5 September 2019

City of Gosford Design Advisory Panel

Proposal: Proposal for Gosford Gateway
Panel Meeting: 27/08/2019

Attachment A – Design Advisory Panel Advice

Northern Elevation - Faunce St Elevation

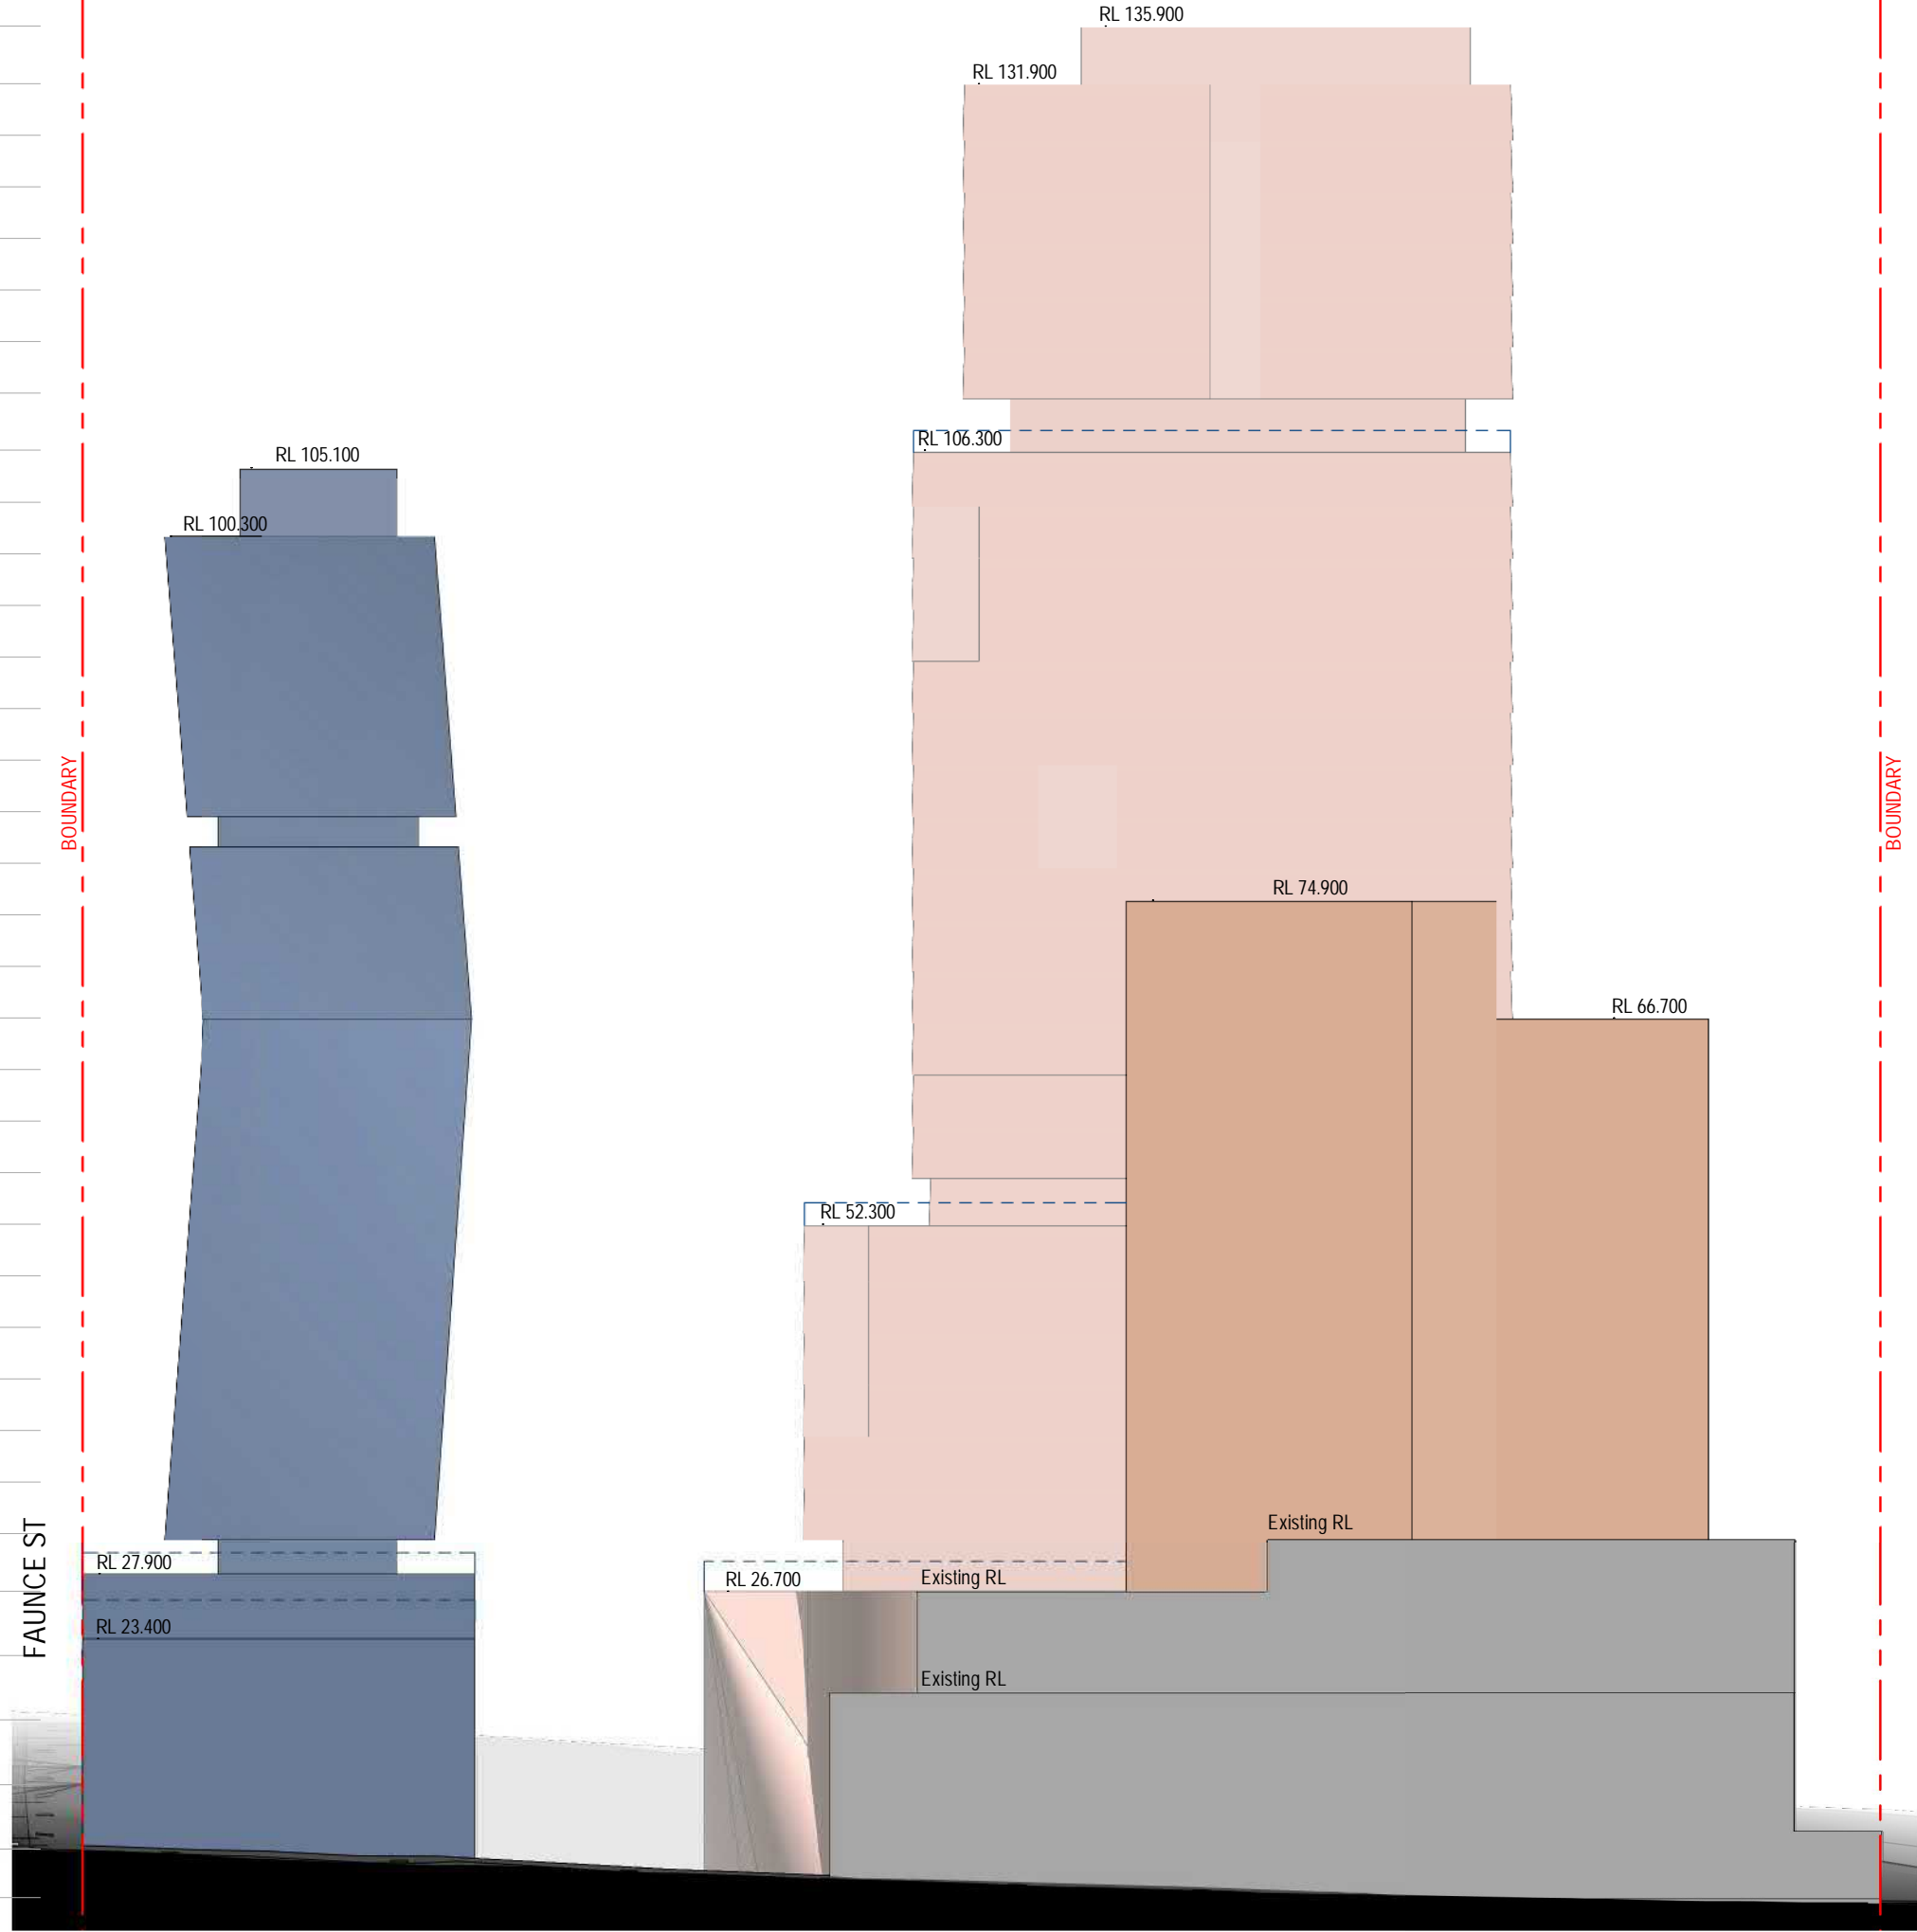
- An image of the proposed Faunce Street frontage (sketch-plan is fine).
 - The overall massing strategy and how it has resulted in building form and the spaces between the buildings.
